**WEST SUSSEX COUNTY COUNCIL
STRATEGIC PLANNING CONSULTATION**

SUBJECT: AL/107/16/RES

Application for Reserved Matters application following Outline Planning Permission AL/39/13 for the demolition of Oakdene and all other structures within the site and the erection of 79 dwellings, public open space, children's play areas, landscaping, drainage measures, sub-station, pumping station and all other associated works.

RECOMMENDATION: ADVICE – NO OBJECTION

Drg No: 160104/MC Rev:

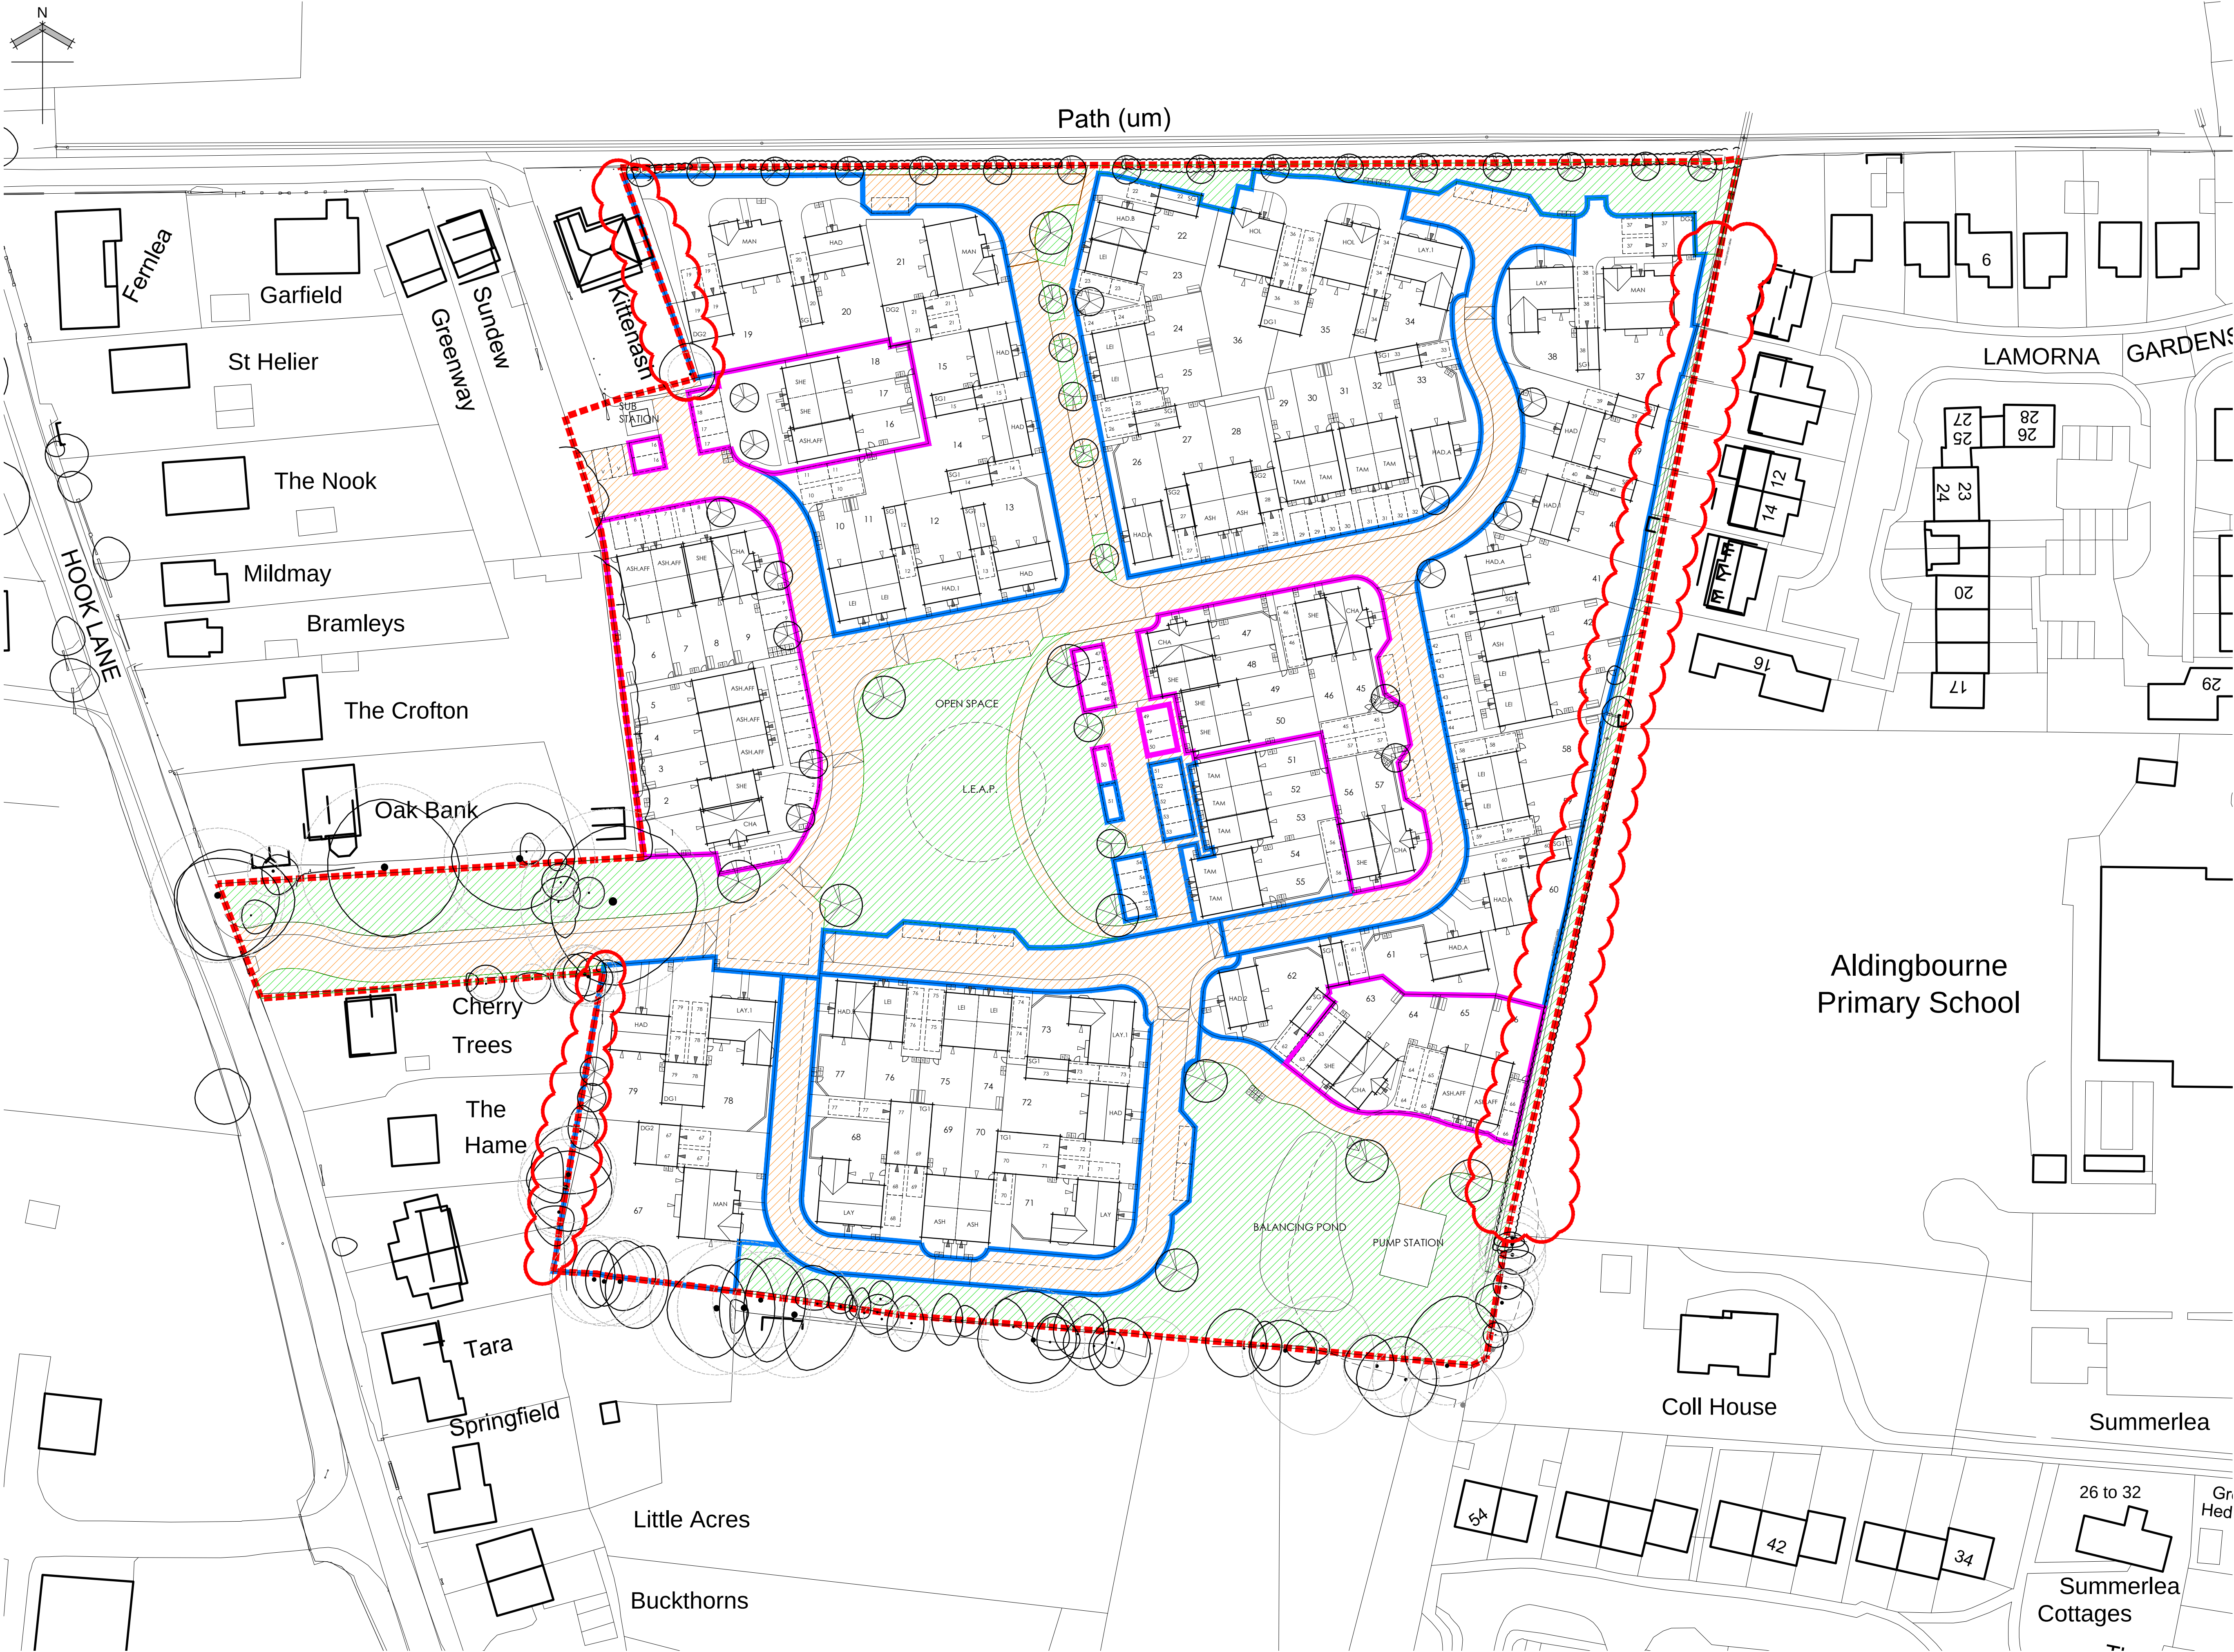
Management Plan drawing 160104/MC indicates that all hard landscaping areas (i.e. carriageways/footways) are to be managed by the appointed Management Company, and are not to be offered for adoption as publicly maintainable highway. The LHA therefore assumes that the internal roads are to be kept private. The LHA have not assessed whether the roads would be suitable or eligible for adoption, and could offer no guarantee of adoption should a S38 application subsequently be submitted to the County Council for consideration.

If the intention is for part or all, or part, of the internal layout to be offered for adoption, the Applicant should provide both an adoptable layout plan setting out the extent of the proposed adoption, and an accompanying Design Audit for consideration by the County Council as part of the reserved matters planning application.

1313-GA-02

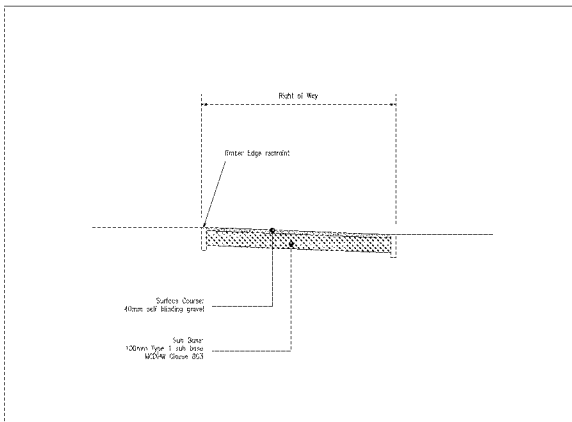
Access to the PROW running east-west along the northern boundary has been provided adjacent to the western turning head. Consideration should be given to whether similar access can be provided adjacent to the eastern turning head, which would provide a more direct route for pedestrians originating from the eastern and southern parts of the development.
